KIRKLEES METROPOLITAN COUNCIL INVESTMENT & REGENERATION SERVICE

DELEGATED DECISION TO DETERMINE APPLICATIONS FOR LISTED BUILDING CONSENT

Reference No:	2023/65/92777/W
Site Address:	71, New Street, Huddersfield, HD1 2BQ
Description:	Listed Building Consent for alterations and signage (within a Conservation Area)
Recommending Officer:	Tom Hunt

Officer Report

Title
GROUND FLOOR SECTION THROUGH ELEVATION

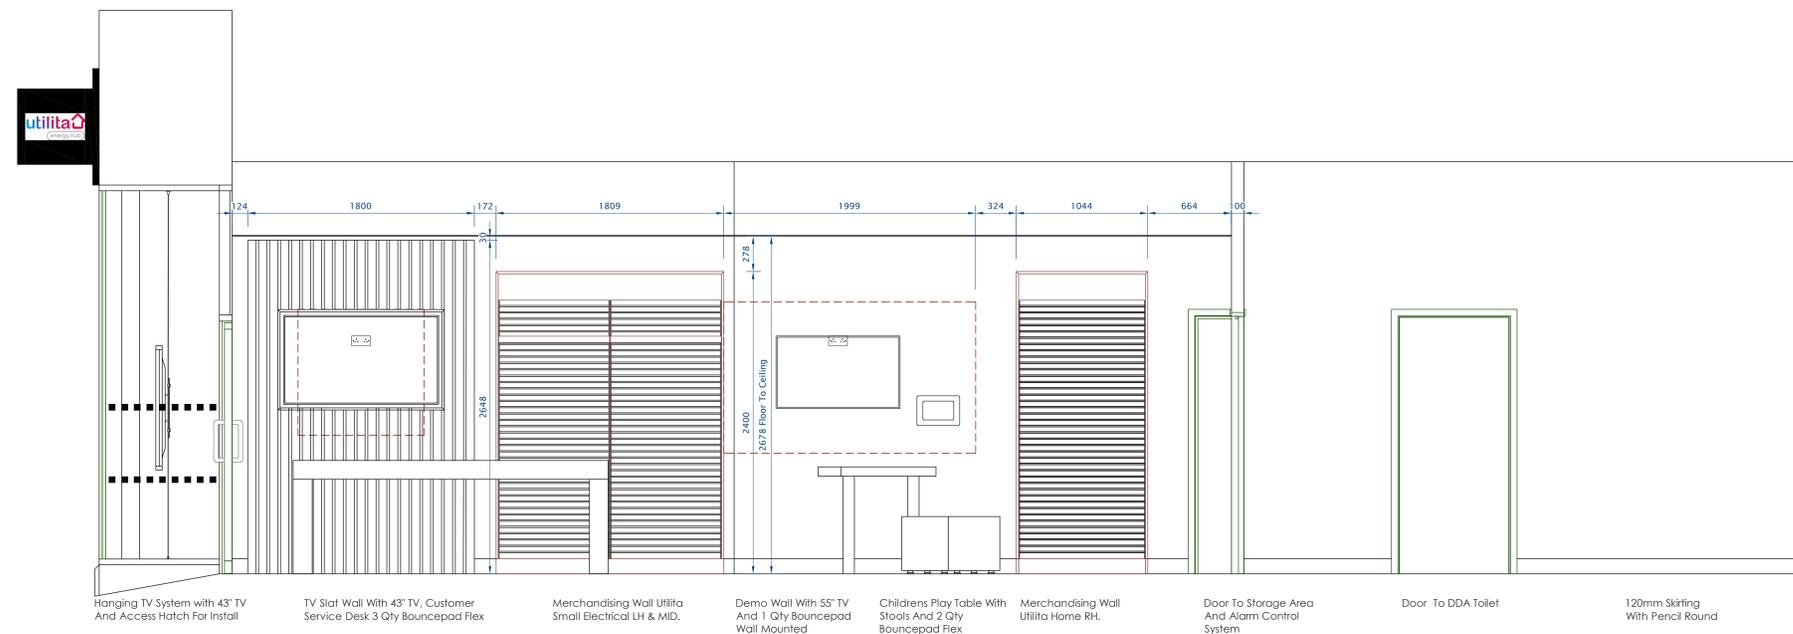
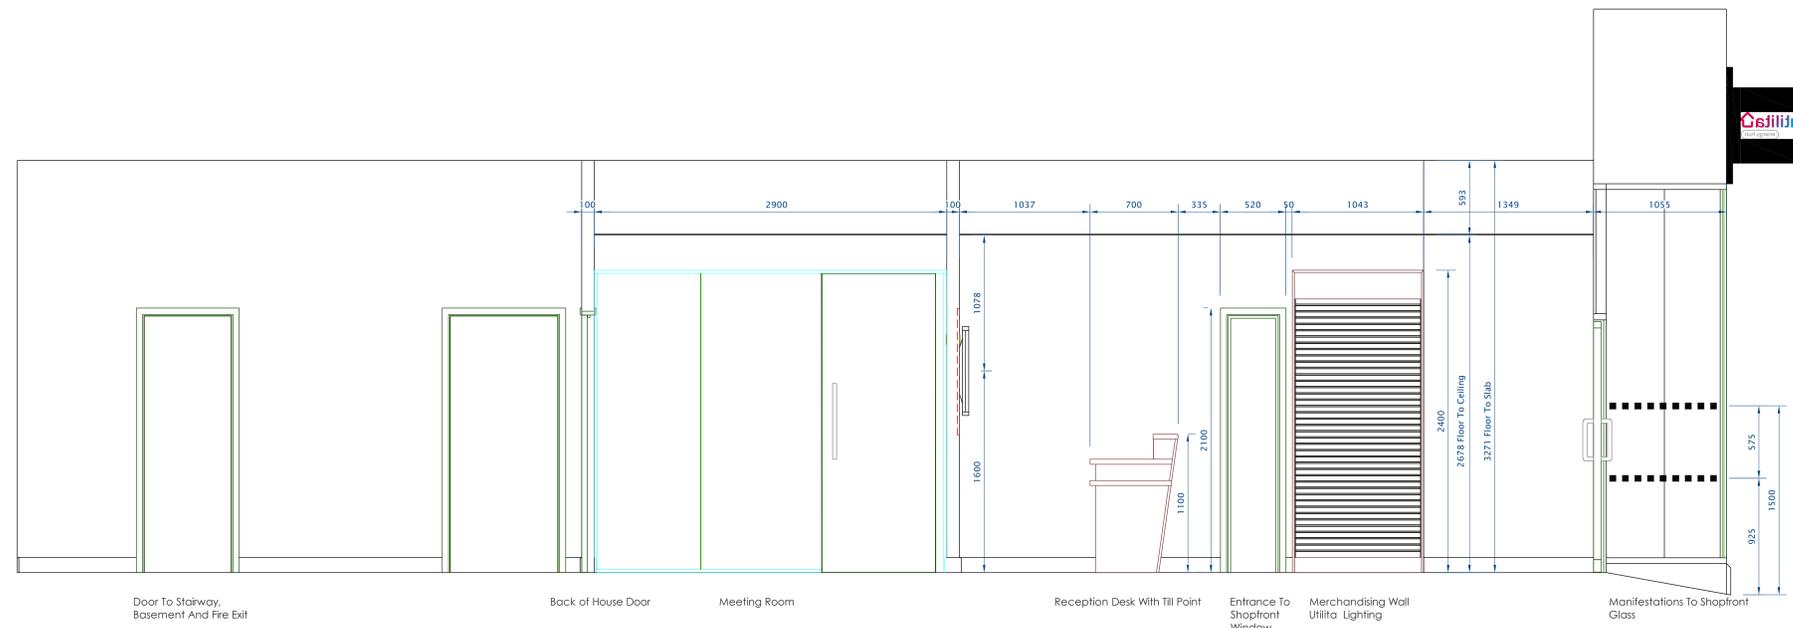
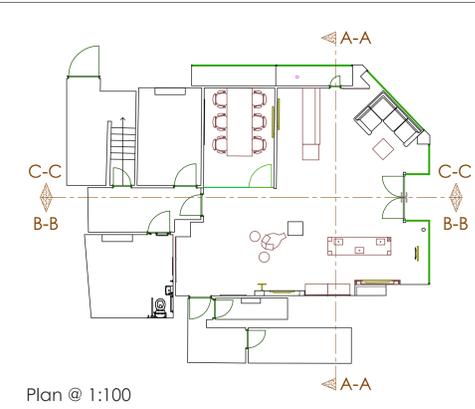
The existing fascia is a timber board with a beaded edging and overhead external strip lighting. Although the existing shop front is a modern intervention, it reflects the design of traditional late 19th century shop fronts within Huddersfield Town Centre Conservation Area.

The replacement fascia would also be with an inset beaded edging to provide some visual depth. The replacement pilasters with beading removed would have a simplified and flatter appearance, however they and the skirting boards were in poor condition and showed signs of rot/water damage. In addition, it is acknowledged that the shopfront is non-historic so there would be no loss of historic fabric. Plans show the finish to be gloss which is not supported by Officers, however a condition to have this to be in eggshell or matt finish should satisfactorily overcome this; the softer appearance of eggshell or matt finish compared to what would be a harsh, reflective and uncharacteristic gloss finish would visually enable the proposed shopfront to appear more sympathetic to the attractive terracotta soft tones of the historic sections of the Listed Building.

The fascia would be lit by external slimline trough lighting, the colour is not specified on plans. Officers note that the limited widths of the trough lighting, compared to the previous full width arrangement, would aid in the scheme's lighting to appear more restrained and less harsh within the Conservation Area. The projecting signage is not set out as externally illuminated on plans. Internal lighting is not supported in Huddersfield Town Centre Conservation Area or others due to its modern appearance. As such, Officers recommend a condition on lighting to be externally illuminated on both the fascia and projecting signage, using slimline trough lighting in a matt white finish and limited to 400cd/m². This would aid in the scheme on a triple fronted shopfront and prominent corner plot to appear well integrated to the heritage assets. Subject to those conditions, the proposal would preserve the character and significance of Huddersfield Town Centre Conservation Area.

3. Notwithstanding the plans received, the fascia signage and projecting signage, including lettering in the logos, hereby permitted shall be in an eggshell or matt finish. The use of gloss finish to signage is not permitted.

4. Notwithstanding the plans received and the application form details provided, all fascias and projecting signage hereby permitted, shall be externally illuminated by slimline trough lighting in a matt, white finish, and limited to 400cd/m² in illumination. No internal illumination shall be permitted to all fascia and projecting signage.
